## Application for a Non-Material Amendment Following a Grant of Planning Permission

Reserved Matters application for the approval of access, appearance, scale, layout and landscaping for 6no. dwellings on approved application 16/02759/OUT.

20/00679/REM

Amendment to garage door on Plot 5

Drawing Title	HOUSE TYPE TWO
Scale	1:50/100
Date	April 2022
Drawing No.	21-13-08
Revision	V

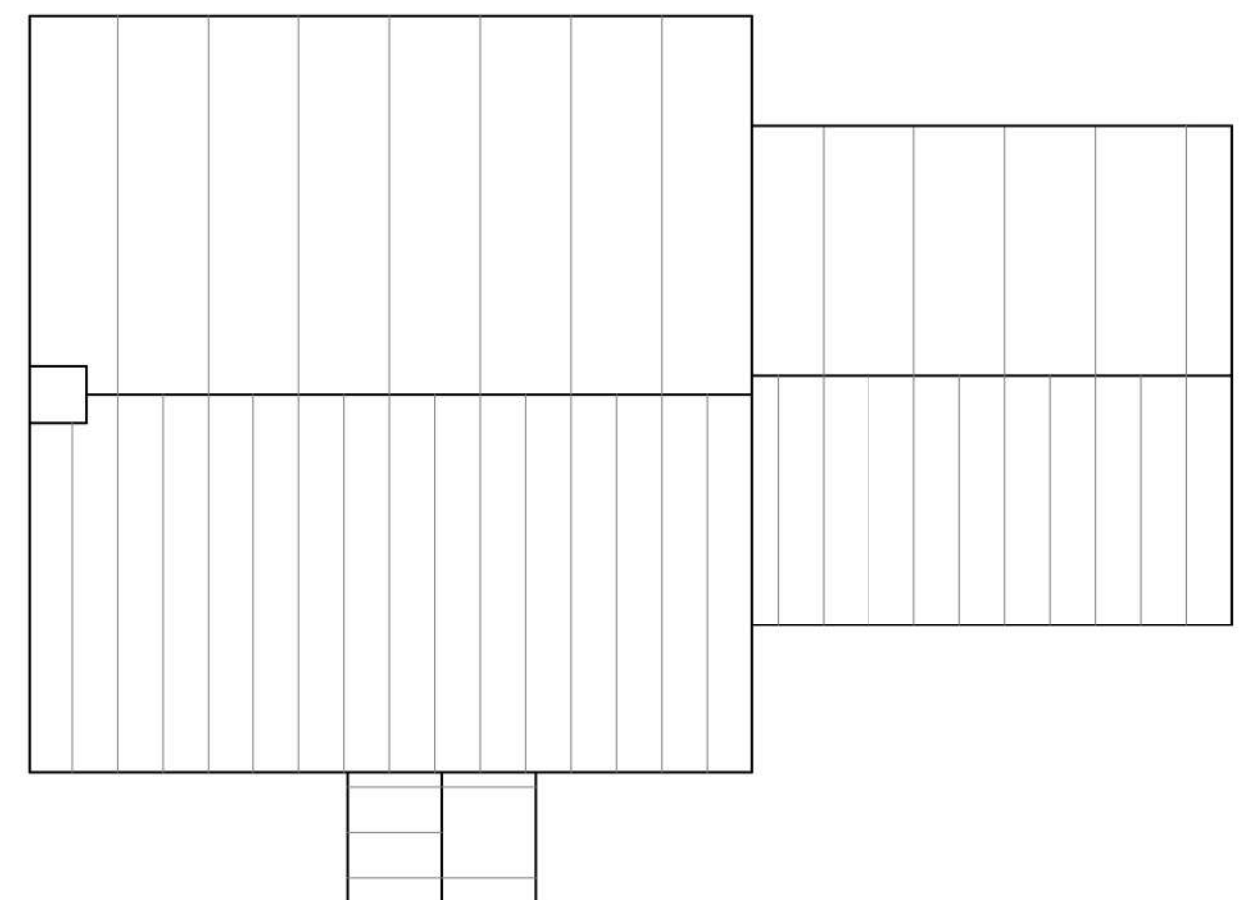
To facilitate easier access to the garage and storage of vehicles

21-13-08 REV T House Type 2 (Plot 5) Elevations
